Planning Application Reference No.: 3/2024/0020

Address of Development: Alston Dairy
Alston Lane
Longridge
PR3 3BL

From: [REDACTED]
Sent: 08 March 2024 13:27
To: Planning
Subject: Planning Application No 3/2024/0020 Commercial retail development Alston

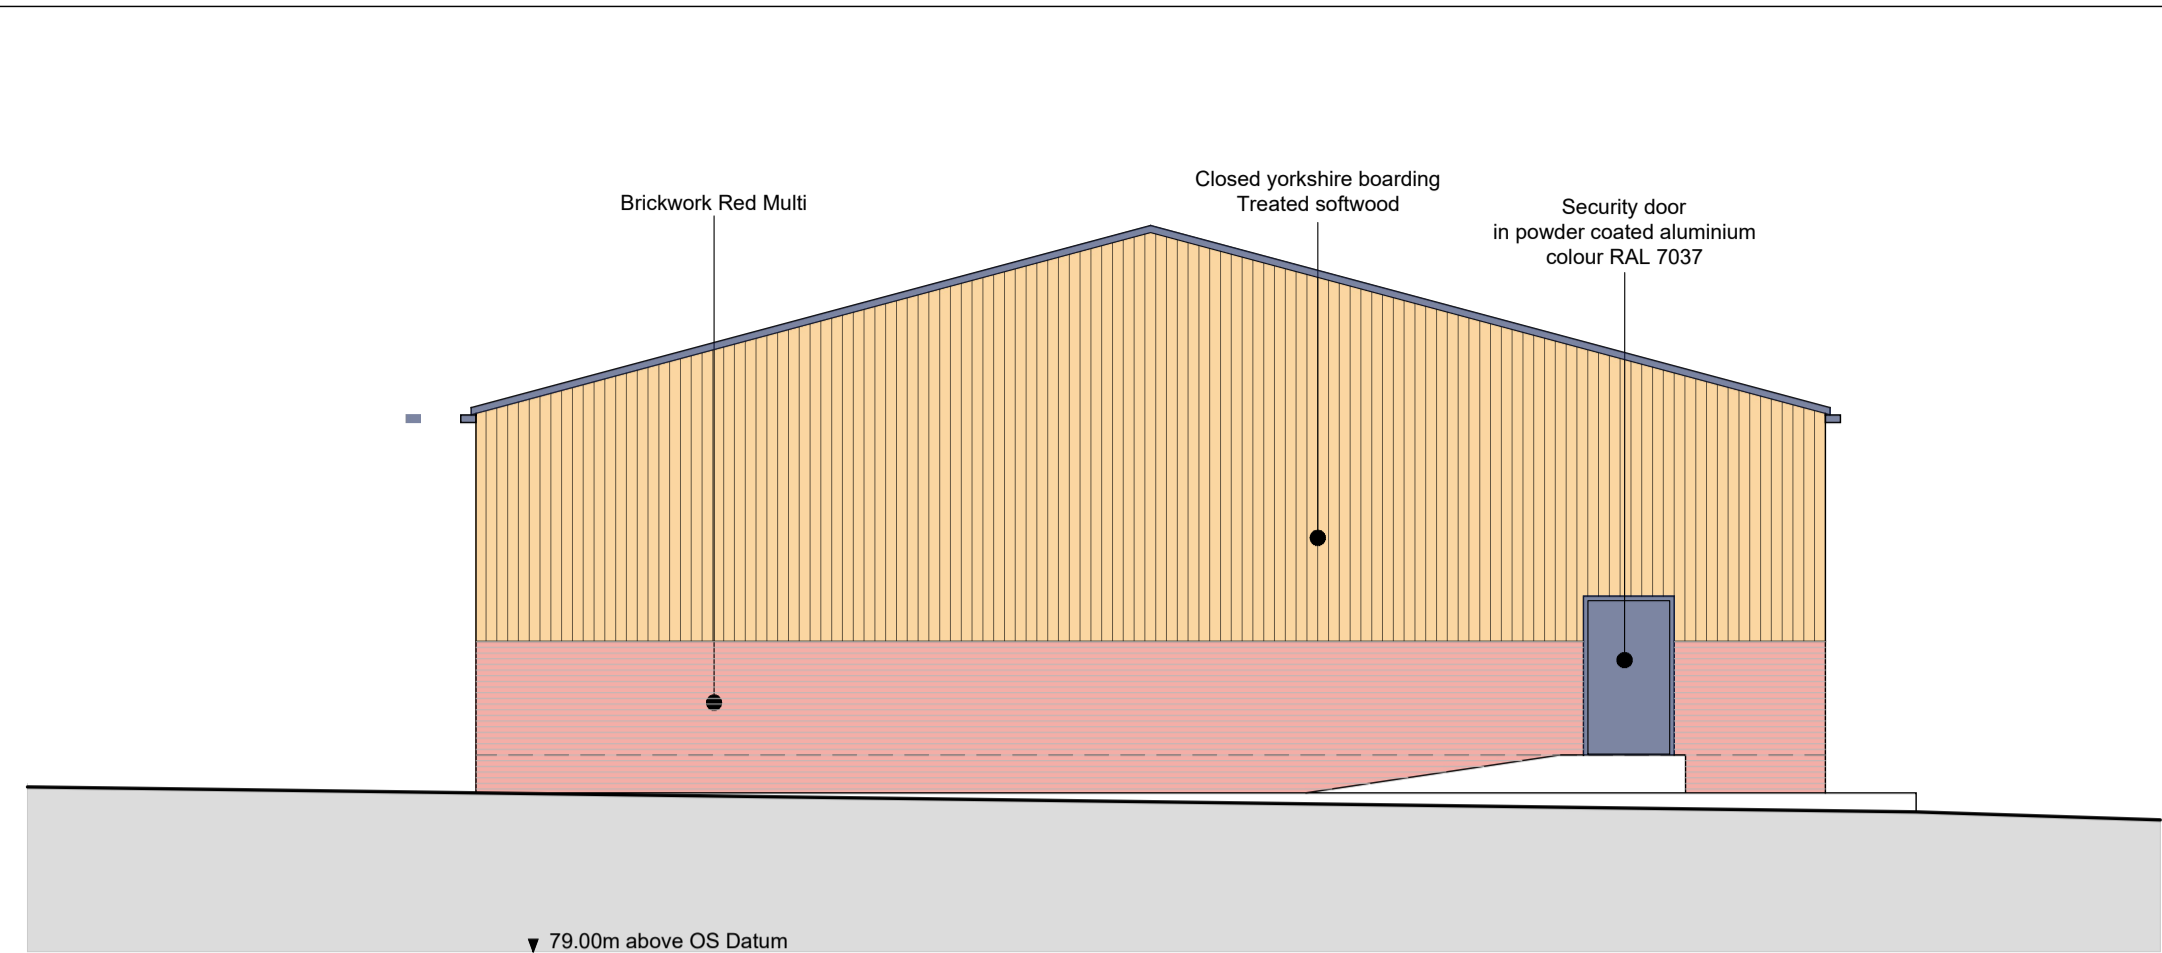
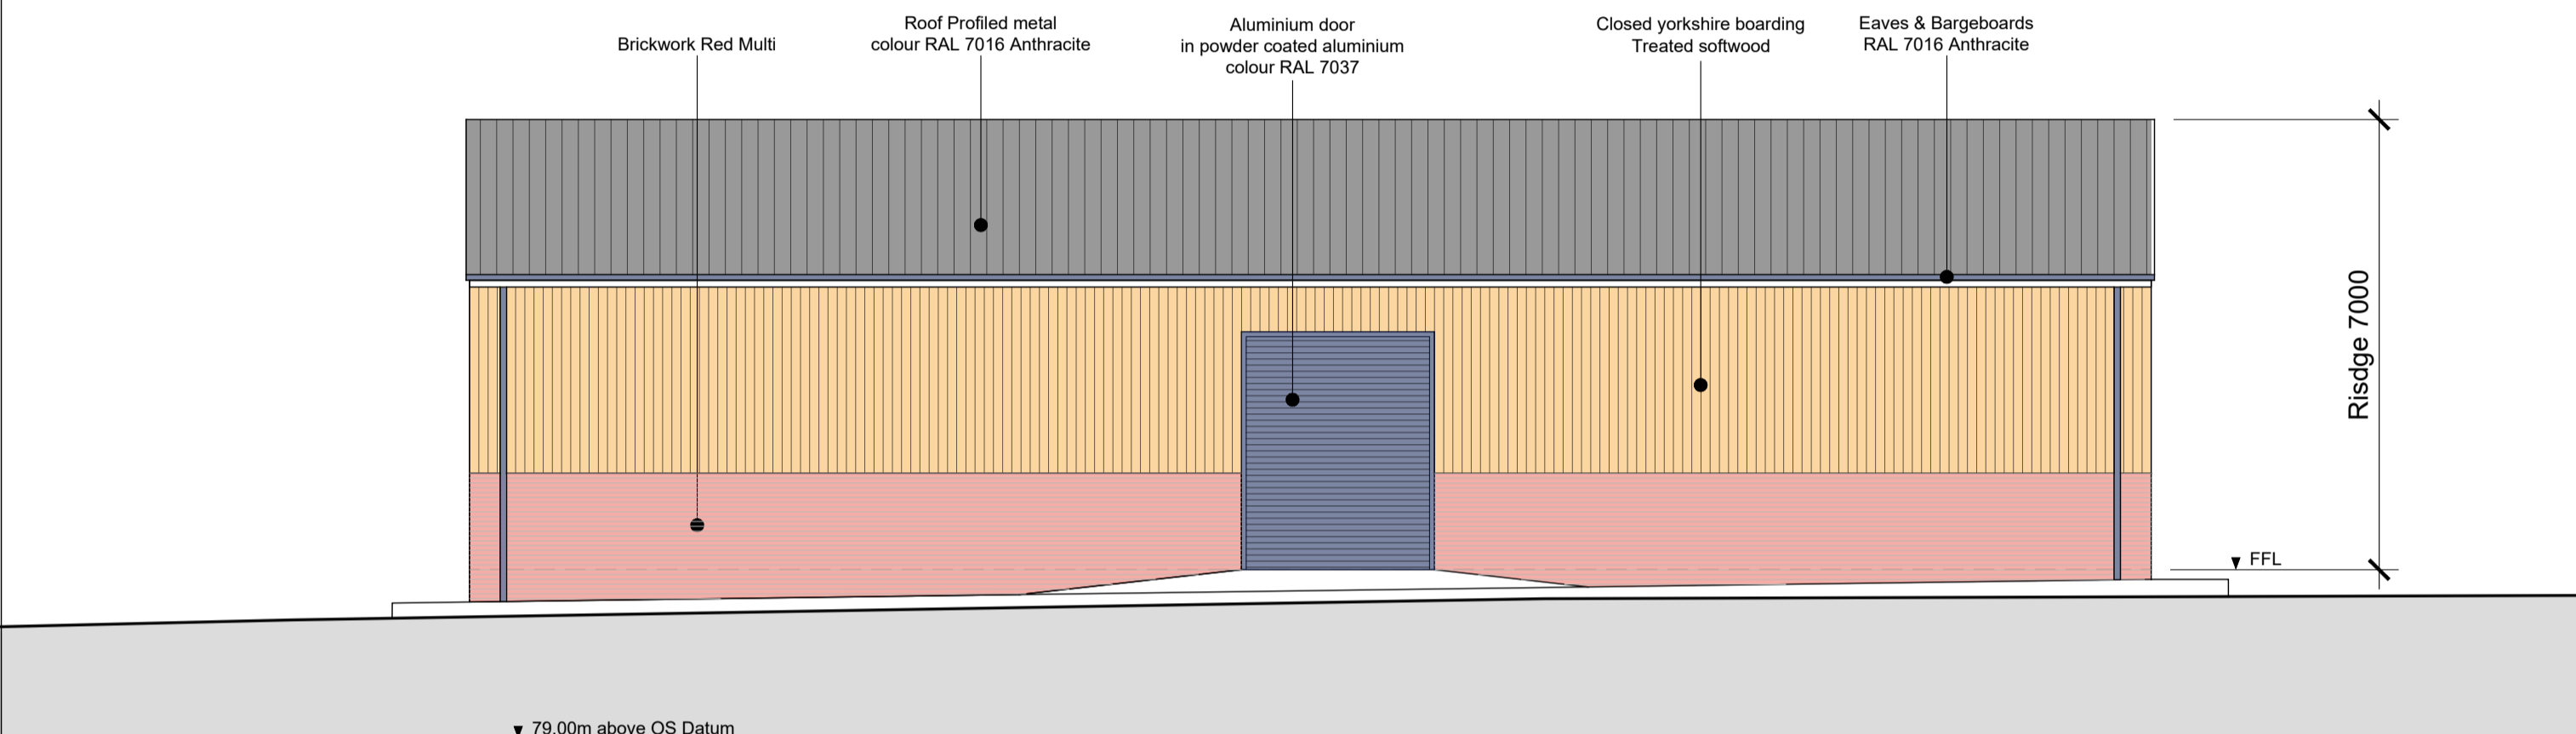
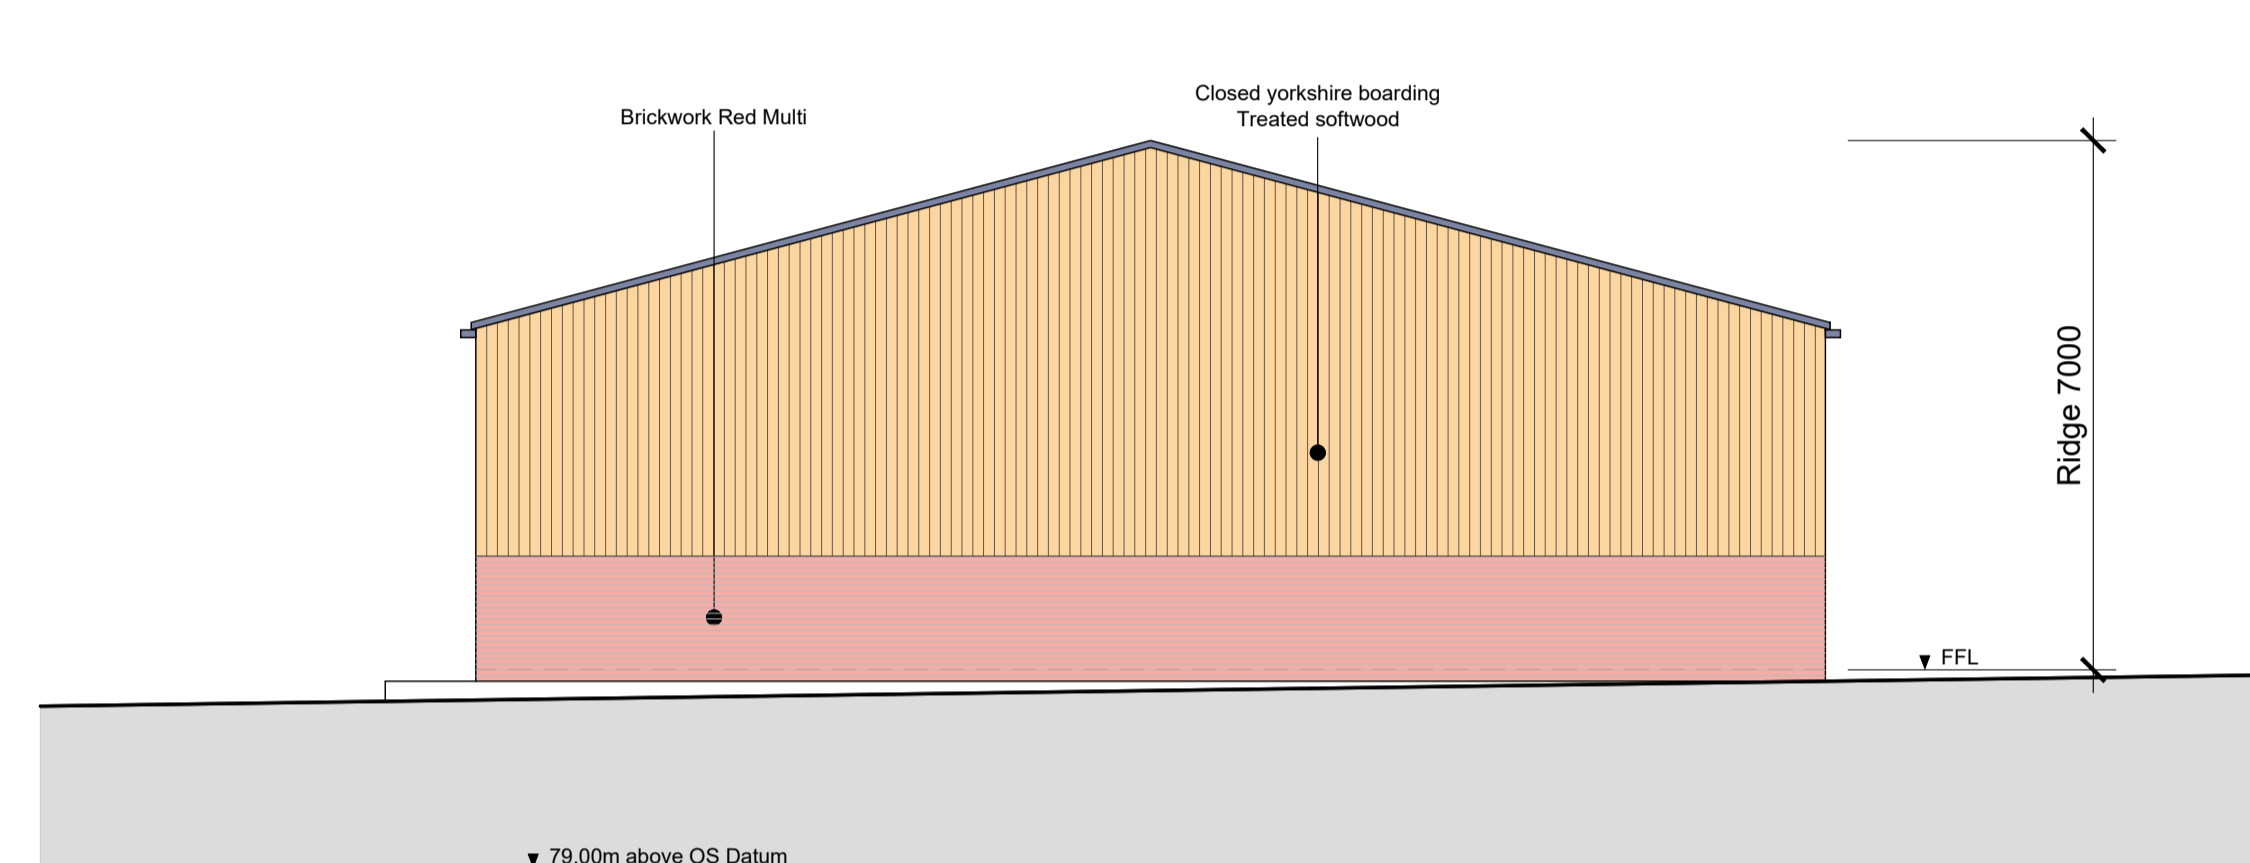
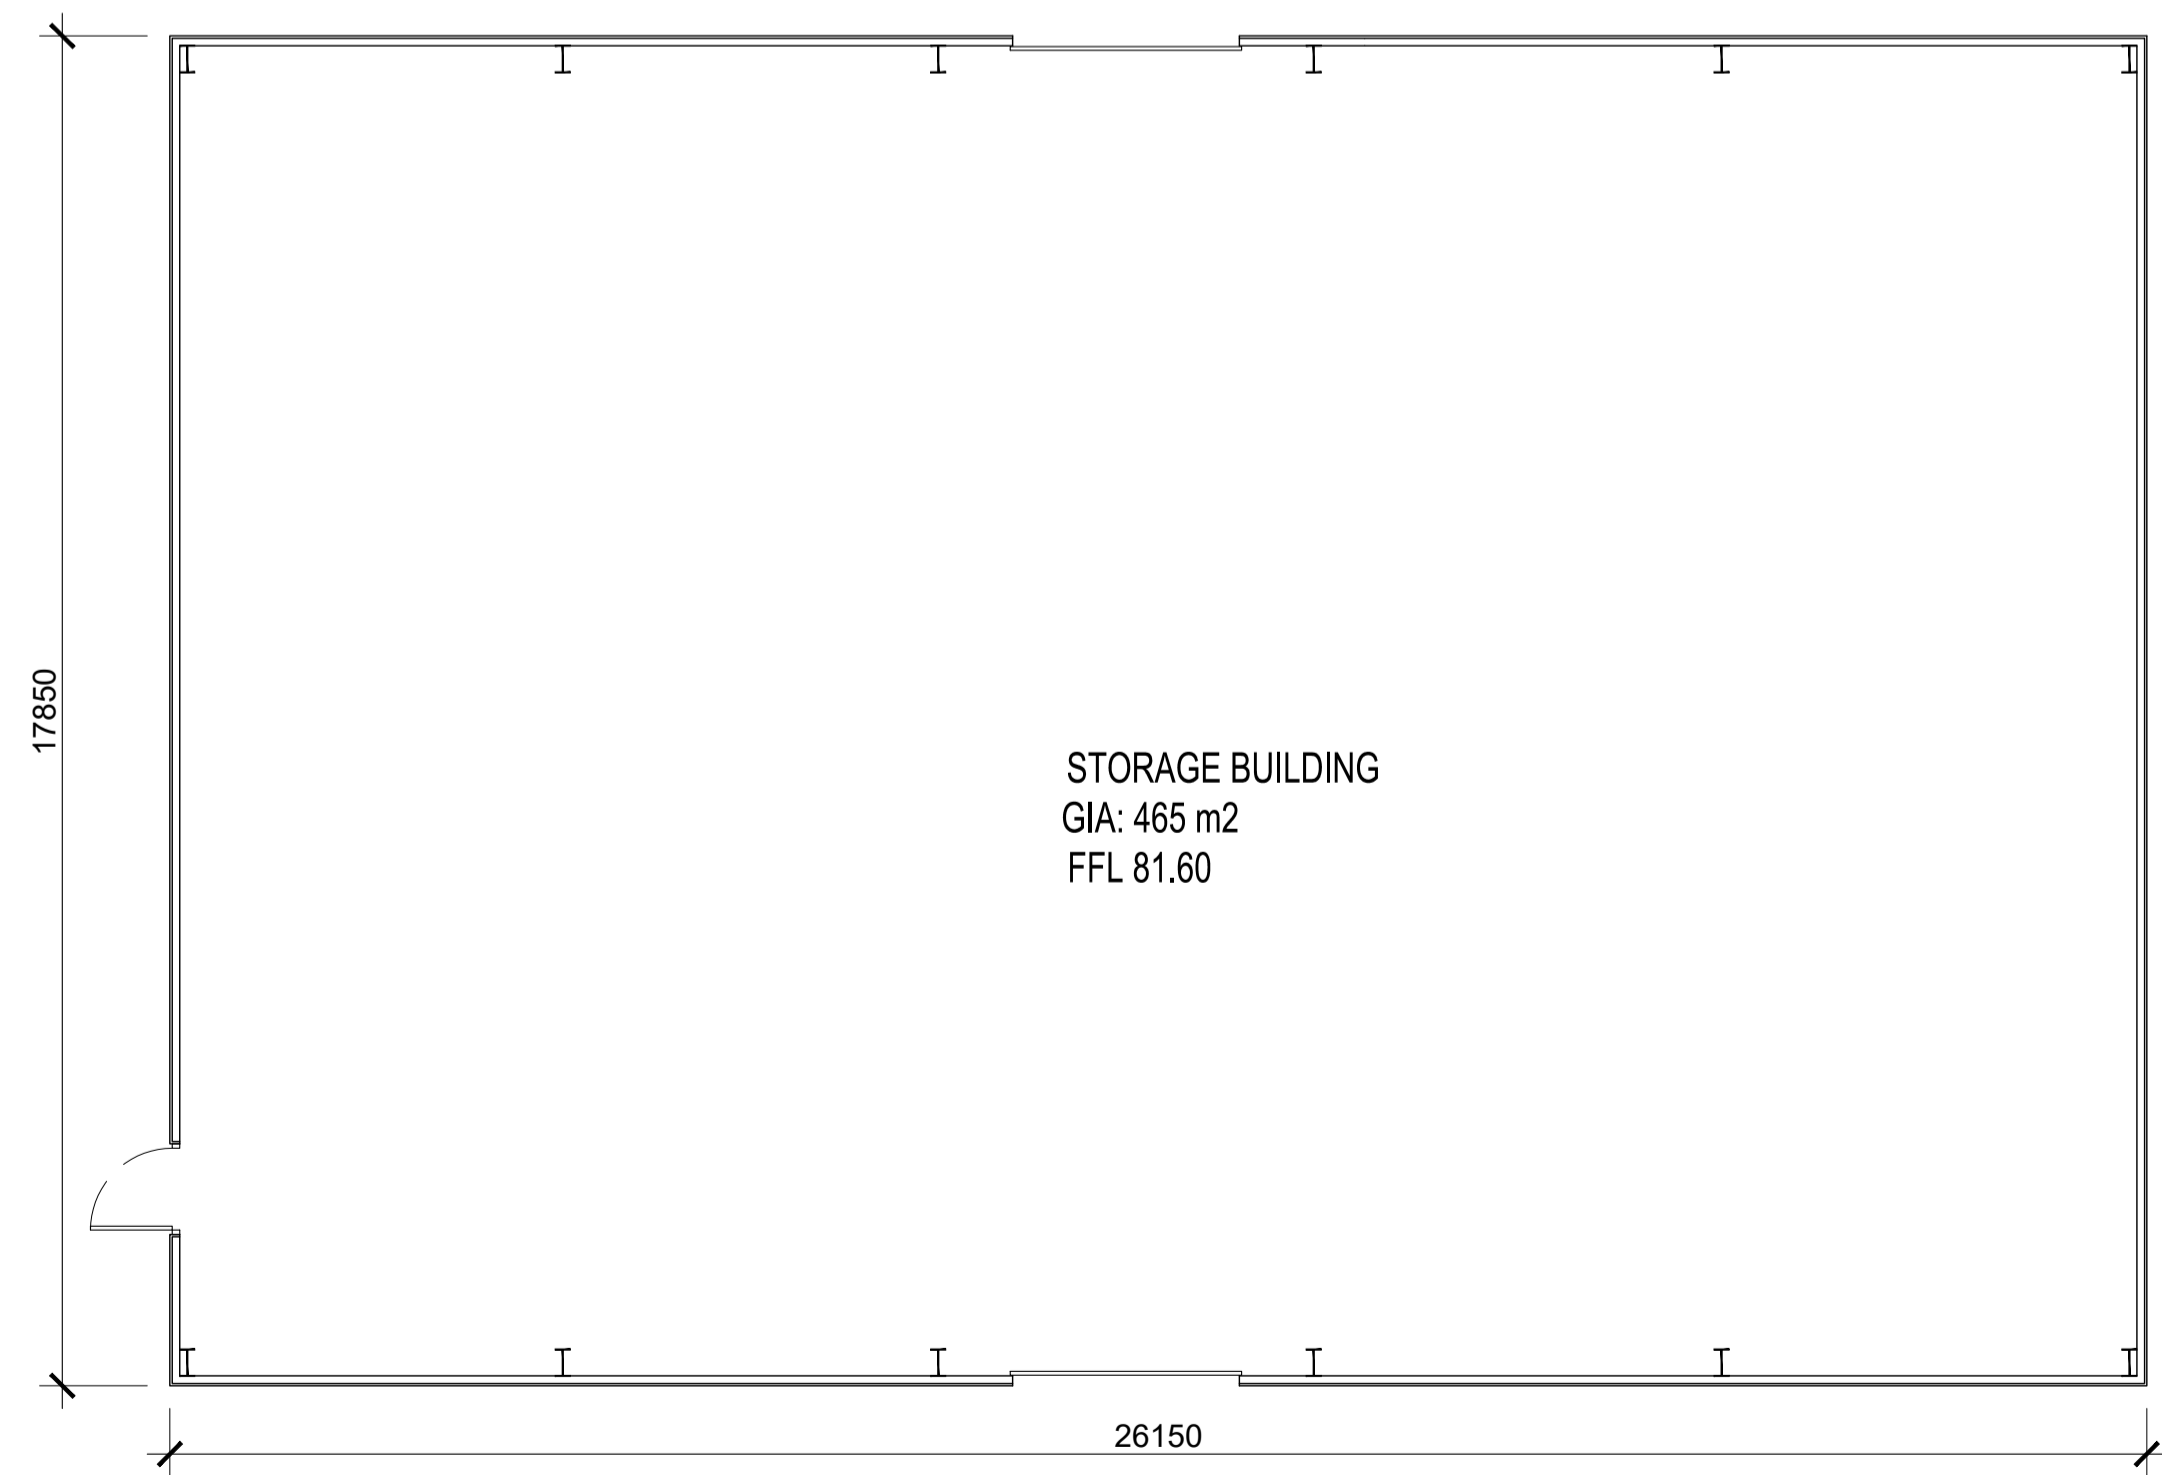
The proposed store, although described in the transport statement as a 'small storage building', is in fact a substantial 465m² structure that would look completely out of place in open countryside, and I can see no valid reason to justify positioning it in that location. If the store is ancillary to the farm shop or dairy, then surely it should be close to the other buildings with access through the existing, more suitable dairy entrance. If not ancillary, it could be sited elsewhere, for example on an existing industrial site or a more suitable brownfield site; somewhere where it would blend in and not be an horrendous blot on the landscape.

I therefore request that you do not support this proposal in its current form, principally because the proposed store is too big, located in open countryside, out of keeping with the area and would cause increased traffic flow through a totally unsuitable junction.

- The storage facility is directly in front of a neighbouring property which seems unfair given the adjacent land available to the west of the proposed storage facility. Whilst we understand that 'rights to a view' do not exist, the storage facility does in our opinion alter the character of the area. The opportunity to locate the storage facility within the existing footprint of the dairy and planned shop seems to make much more sense. The current separated development away from the dairy does nothing to protect green space as it creates a development discontinuity. How much more open green space are we willing to lose?
